# DRAINAGE LETTER

## LOT 11, ROLLING THUNDER BUSINESS PARK

April 2, 2021  
Revised  
September 24, 2021  
Revised  
December 24, 2021  
Revised  
May 27, 2022  
Revised  
June 14, 2022  
Revised  
August 1, 2022

County File No.: PPR-21-24

Scale 1" = 20'  
Contour Interval: 1'

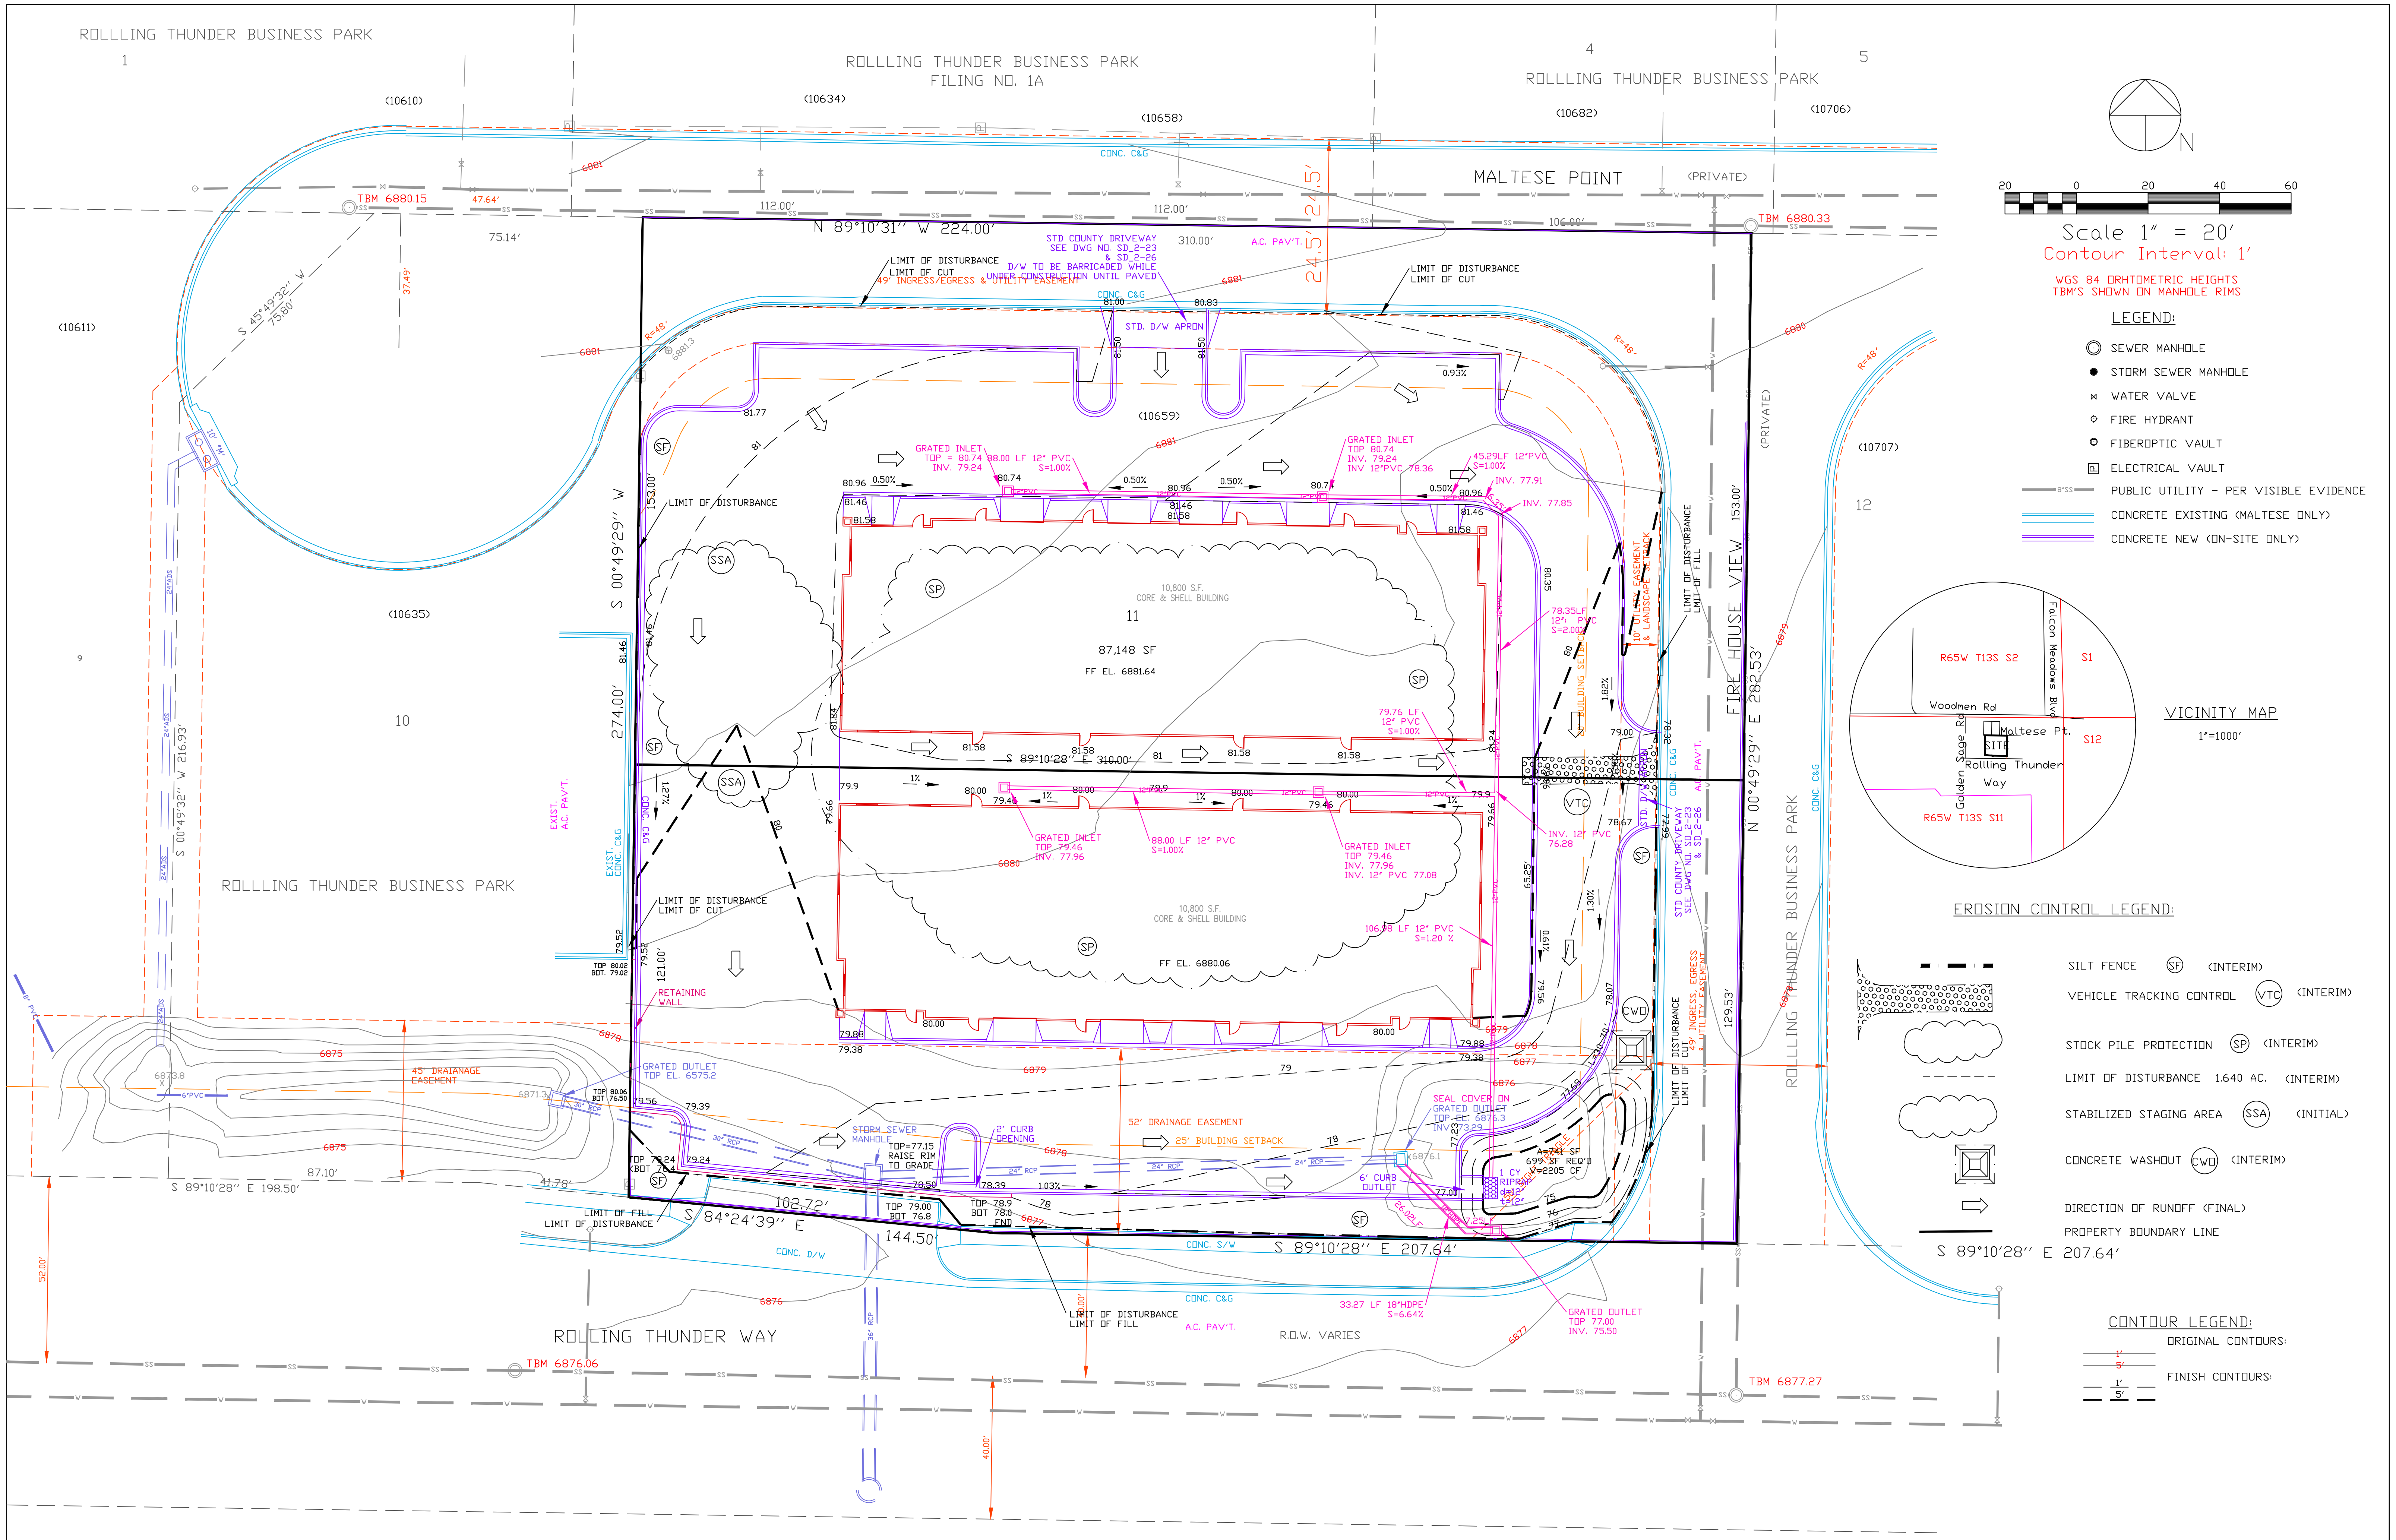
There is no proposed storm sewer north side of the northern building. Unresolved.

Orifice size does not match UD-BMP Form Unresolved.

remove and adjust the following sentence to account for removal

The adjacent lot only has a WQ pond. Please see notes below outfall from these WQ ponds. Statement will need to be corrected.
